SUBMISSION AS THE LOCAL PLANNING AUTHORITY

1.1. The following information is submitted in response to the information submitted at Deadline 4 by the Applicant (National Highways) for the A46 Newark Bypass for an Order granting Development Consent. Our comments follow the Council's Local Impact Report (REP1-035), Written Representations (REP2-051), response to ExQ1 (REP2-050), comments on Deadline 2 submission documents (REP3-046), namely the Historic Environment and Visual Impact Assessment (REP2-020) and our representations at Deadline 4 REP4-045 (Written summaries from the hearings) and REP4-046, 047 and 048 (Responses to further information).

1.2. The comments made for Deadline 5 are made by Newark and Sherwood District Council in their statutory role as the Local Planning Authority (LPA) and not as landowner. Newark and Sherwood District Council, in their landowner responsibility will not be making any comments for this deadline and it is understood that discussions on land acquisitions are still ongoing.

Photomontage 25: Year 15 in operation (planar projection, field of view 39.6 degrees x 27 degrees, to be viewed at A3)

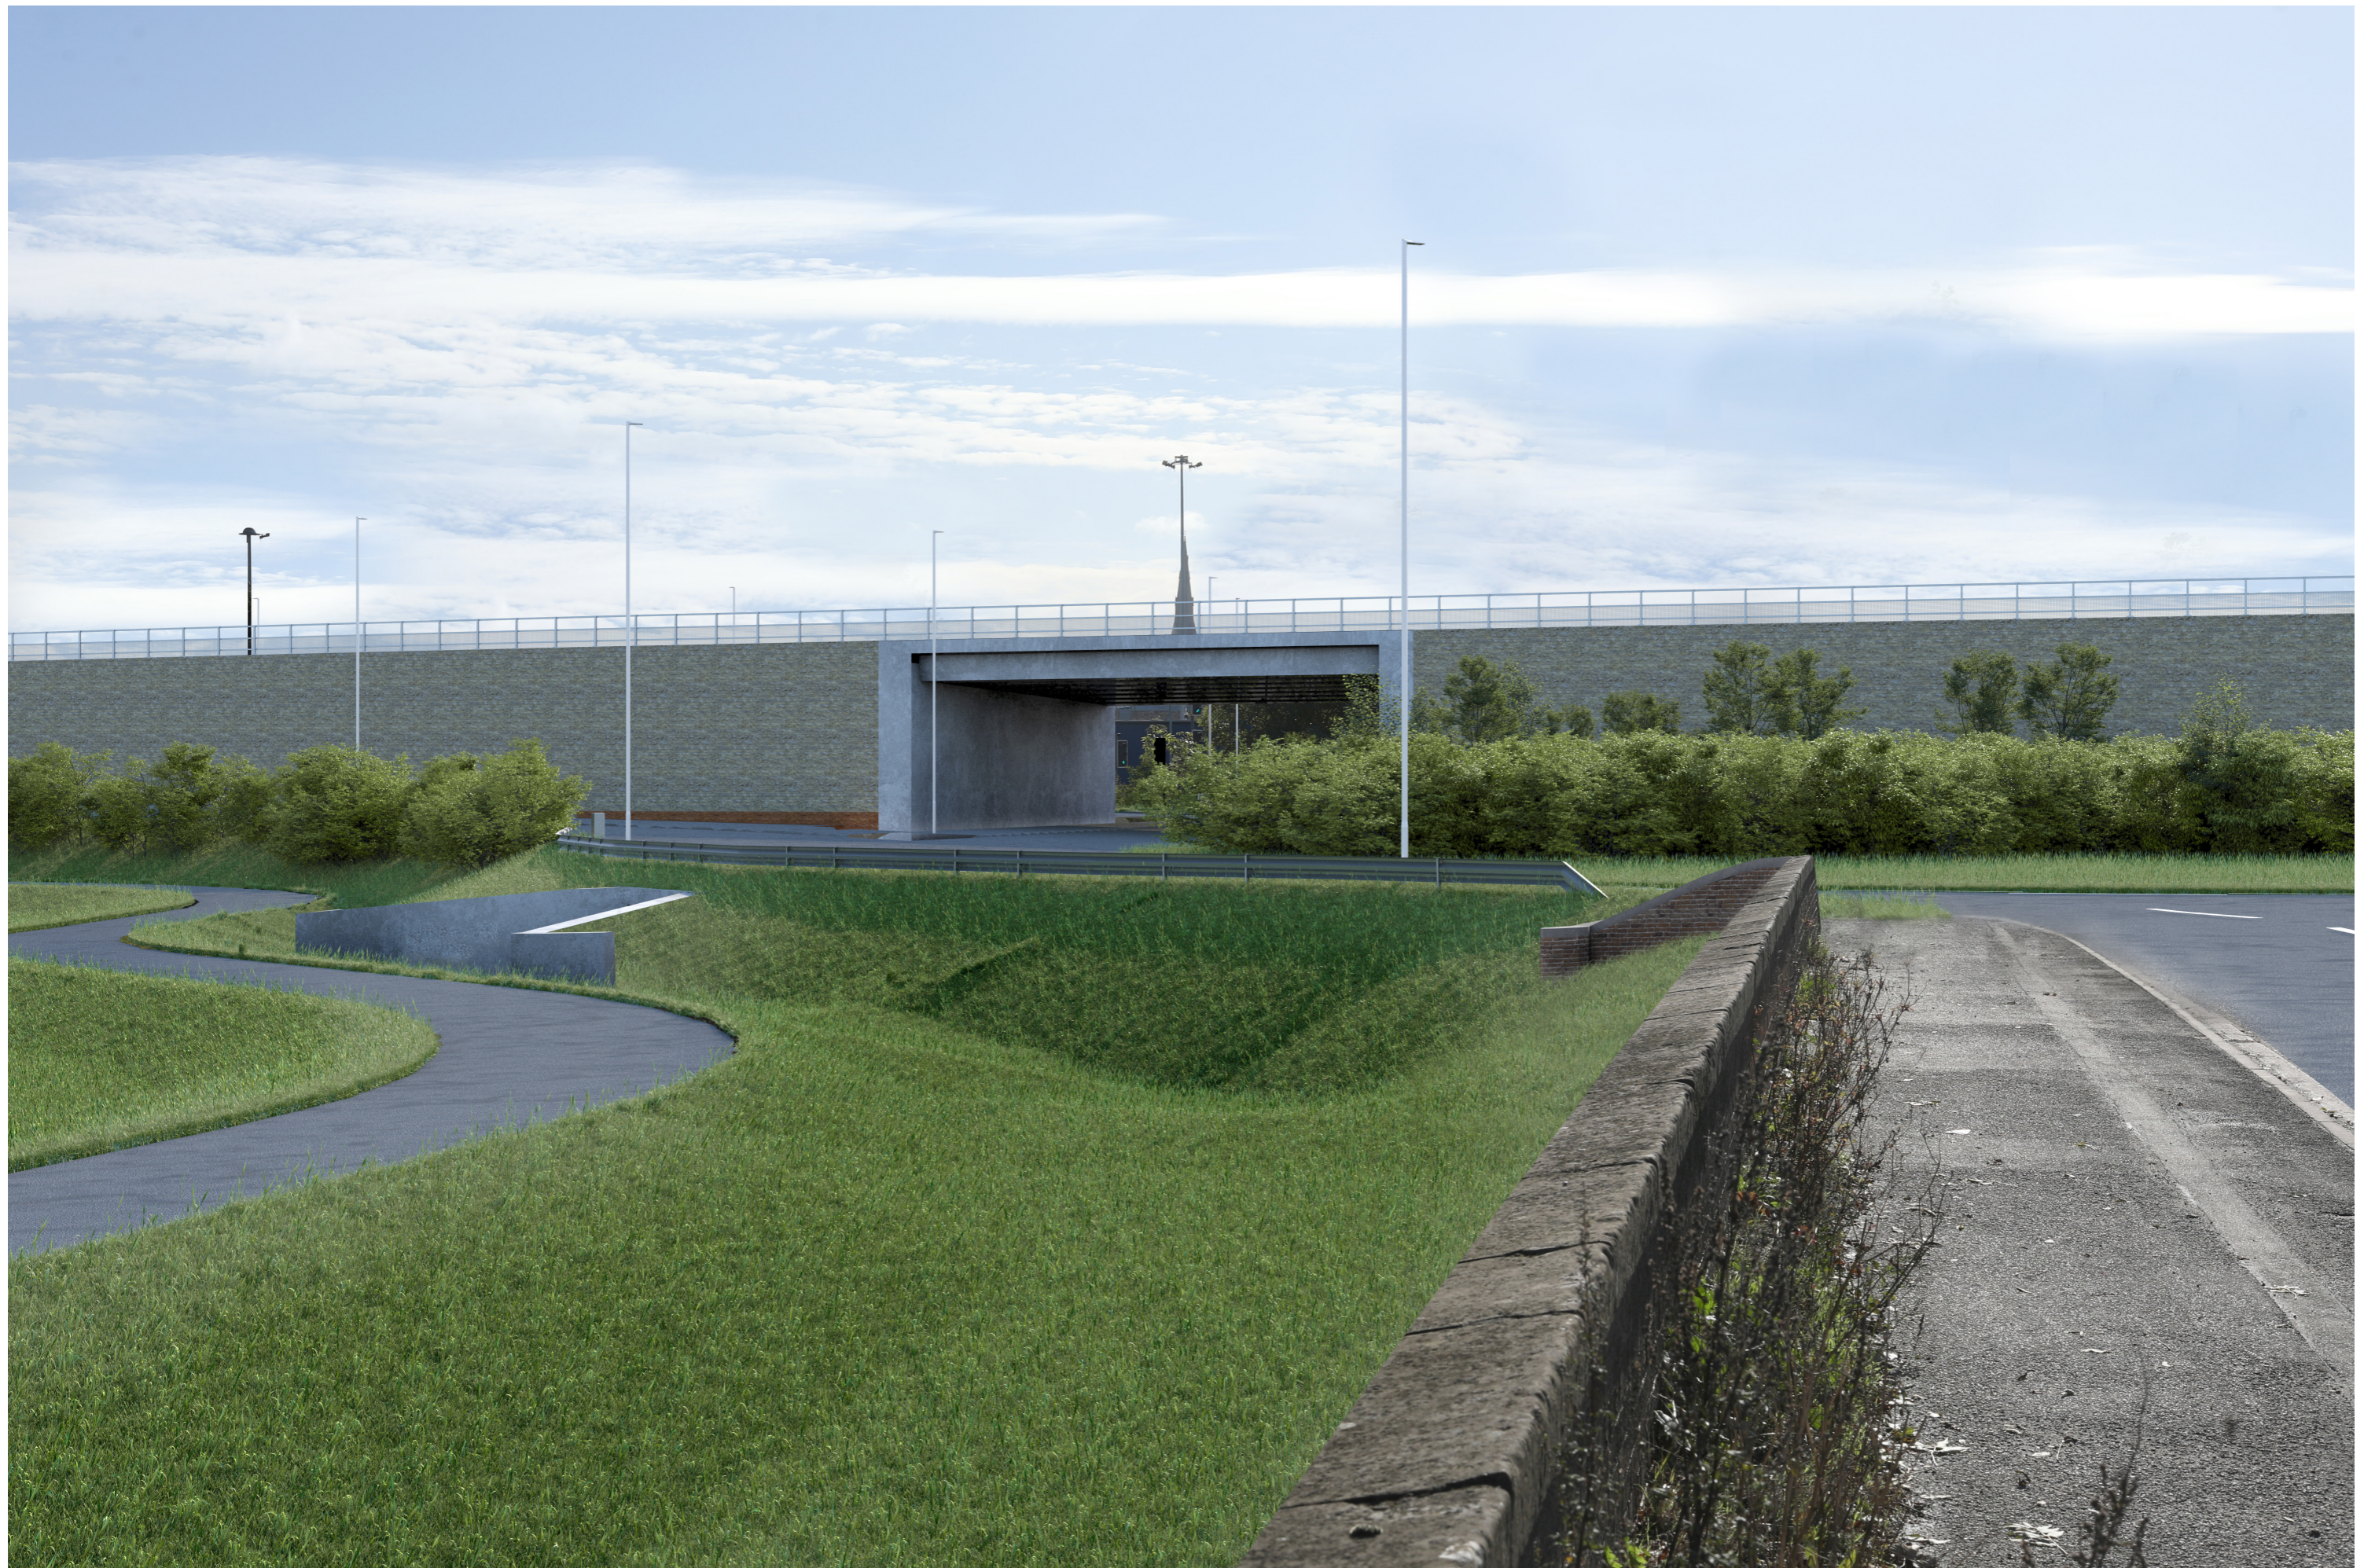
- 2.10.** The update to Viewpoint 25 to show the amended layout to Smeaton's Arches is welcomed and we have no further comments to make on this point.

2.14. Turning now to the Smeaton's Arches approach, south on the A616. It is accepted that the viewpoint and visual representation is most likely not taken at the most appropriate position in order to illustrate how the Scheme would make use of the existing vegetation. Instead a position further north-west would have shown the bank

of trees, outside of the Order limits, being retained. However, we were fully aware of this area remaining when we have raised our previous comments, and it has therefore not been ignored. Our main concern, as reiterated previously, has been the land adjacent to the highway and around the edges of the roundabout. The applicant has stated that the scheme has been designed in full accordance with the information within LD117 (version 0.1.0) which is a National Highways document for the design manual for roads and bridges. However, at its heart this document states that *Integration and minimising the impact of disturbance of new roads within the rural or urban landscapes and improving the landscape character of existing roads is the basis for good environmental landscape design*. Stated within this document are the principles and purpose to the design which includes enhancing and improving the landscape quality and environment and creating opportunities to conserve and enhance the landscape character. In addition it states that excellence in landscape design should also be inclusive in respect of places, people's needs and **views**. Within this document also it states that designs should take account of the maintenance, management and operational requirements where shrubs are planted within 4.5m of the edge of carriageway, medium sized trees no closer than 7m (girth less than 450mm) and climax trees (girth greater than 600mm) not within 9m, **unless otherwise agreed by the Overseeing Organisation** (para 3.4.1) (emphasis added). Who is this Overseeing Organisation and if they can override the document then this must be for valid reasoning. In our opinion additional planting adjoining the A616 is necessary to frame those views on the approach to the Cattlemarket roundabout, even despite the trees remaining beyond the Order limits.
